07 November 2018

RE: SIGMA PHARMACEUTICAL WAREHOUSE & DISTRIBUTION FACILITY MODIFICATION (SSD 7719 MOD 2) - RESPONSE TO SUBMISSIONS

Figure 6 | Approved (left) and Proposed (right) Site Plan

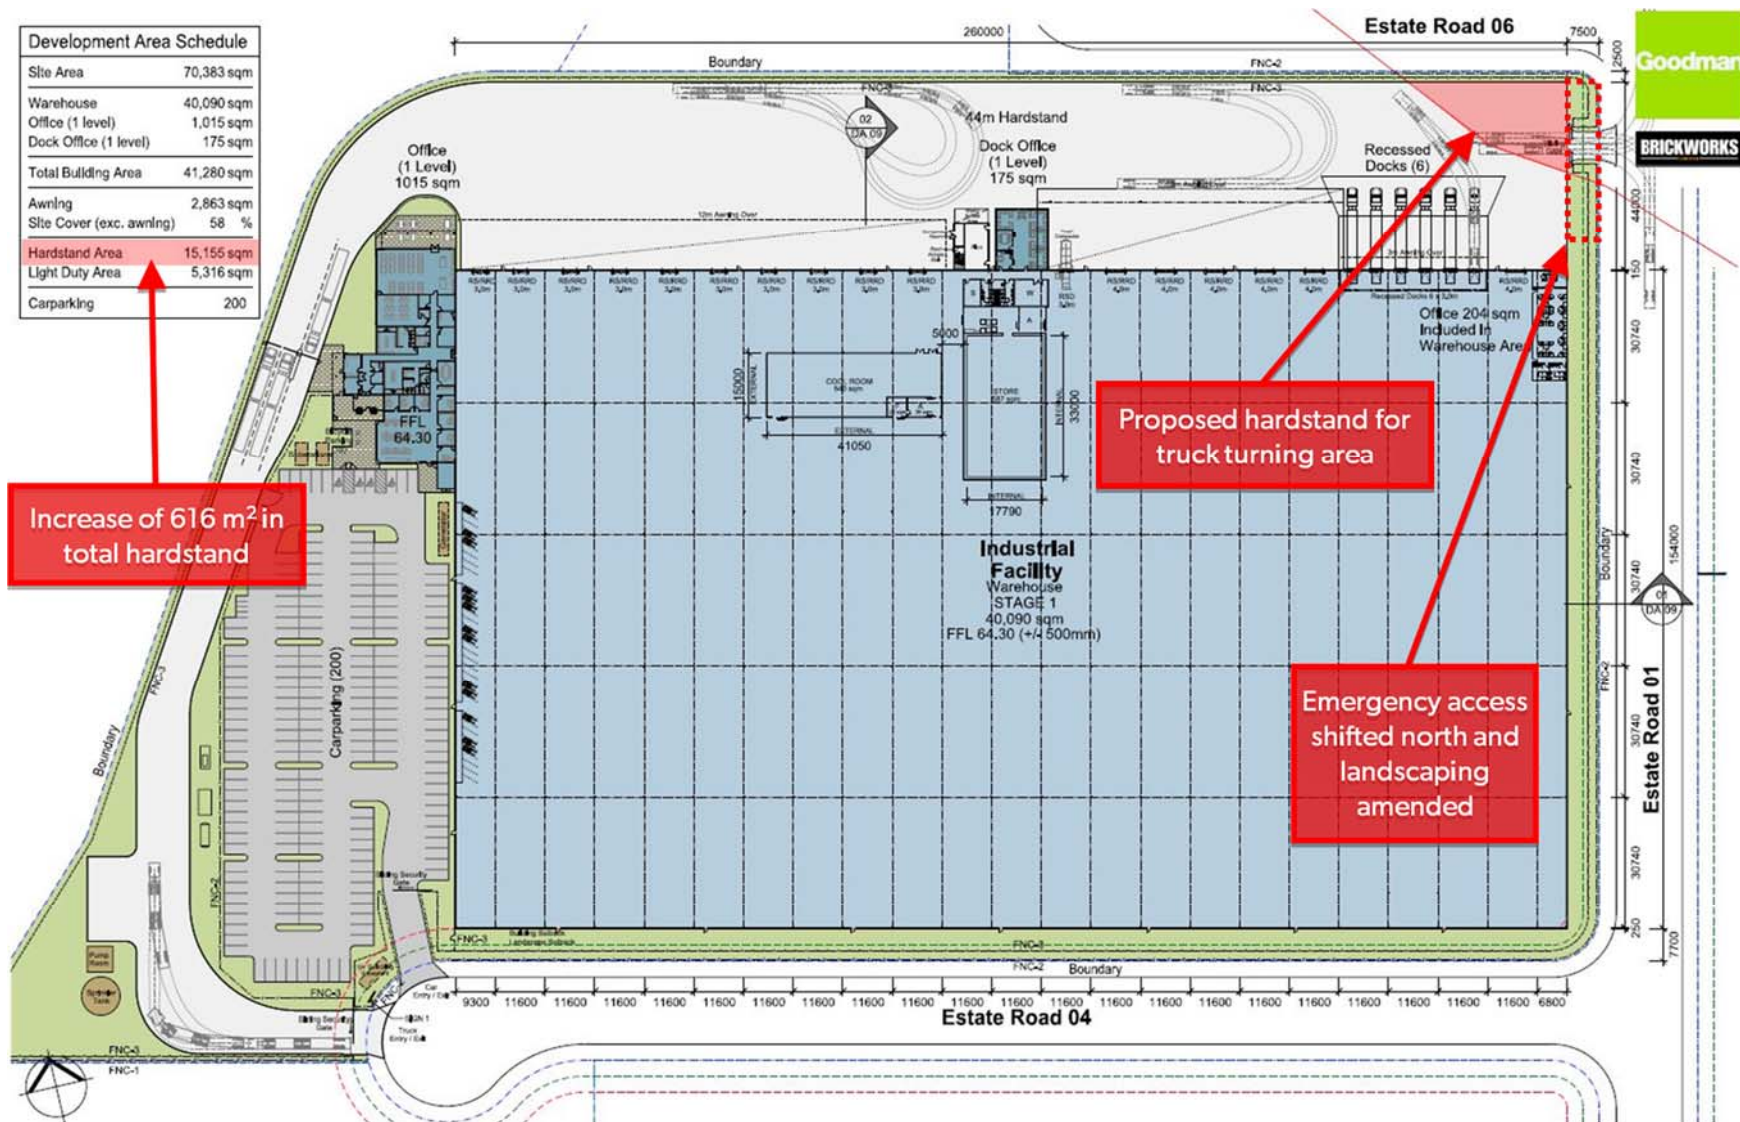
- *It is also recommended that the access driveway to Estate Road 01 be relocated to Estate Road 6 to provide an unbroken landscape connection along Estate Road 01 for the full width of the lot. This would suitably address the landscape character of this road as well as sites relationship to the E2 zoned land further east. This option may still enable the proposed 2.5m landscape setback to Road 06 further north of the intersection, away from the intersection which is the primary view corridor within the development.*

SSD7719 has approved the vehicular crossing to Estate Road 01, albeit slightly further to the south of what is now proposed in this modification application. The crossing to Estate Road 01 ensures clear manoeuvrability of vehicles across the hardstand area and will minimise vehicular conflict within the site. Traffic modelling and assessment that informed SSD7719 confirmed that the crossing location is suitable onto Estate Road 01 and will not affect traffic flows along that roadway through the estate. The increased landscape zone and quantity of planting fronting Estate Road 01 will improve the landscape amenity along this frontage from that originally approved.

Figure 7 | Approved (left) and Proposed (right) Landscaping

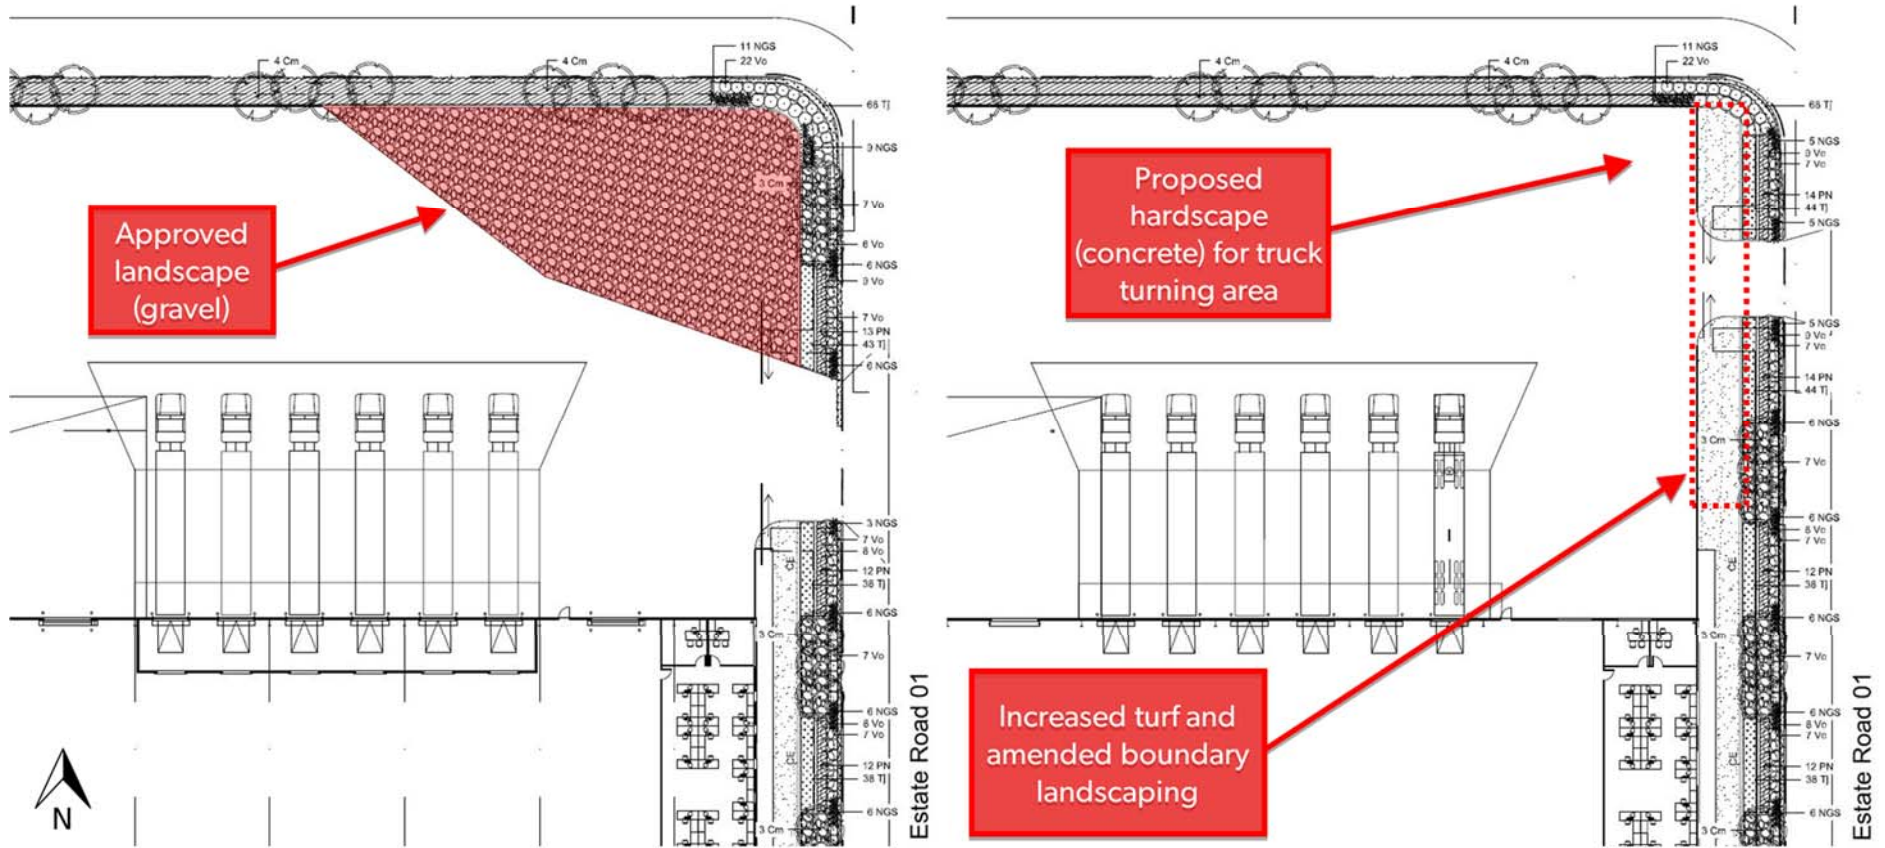
- *While the rezoning may be appropriate given the approved road configurations, the proposed extent of additional hard stand area now proposed is not considered to be appropriate at this intersection and an improved landscape setback between the property boundary and car parking areas should be required.*

- *The proposed plans provide for a 2.5m setback to Road 06 which is inadequate given the location of this site. The corner of the site (south east) requires an embellished landscape setback to frame the intersection of Estate Road 6 and Estate Road 1 which is planned to be embellished to the east and south. The extension of the hard stand out to the intersection area does not suitably respond to the contextual planned landscape character of this intersection, and an increased setback should be provided.*

Figure 1 demonstrates that SSD7719 MOD 2 increases the amount of turf and soft landscaping along the setback in the south-eastern corner of the site from 4m to 7.5m. This is considered an

improvement to the visual presentation to the corner and street frontages, in comparison to the approved SSD7719 landscape plan. The addition of turf and soft landscape to the corner creates consistency with the existing landscape setback along the Estate Road 01 frontage.

We note that the approved landscape plan for SSD7719 includes ballast (gravel) at the corner which is visually substantially the same as the hardstand area. The difference being that it is no longer a permeable surface. Views to the hardstand area will be appropriately mitigated by the increased (7.5m) landscape setback that is comprised of turf and layered plantings along the eastern boundary. For these reasons, the landscape treatment is considered to be not only appropriate but an enhancement to the south-eastern corner of the lot.
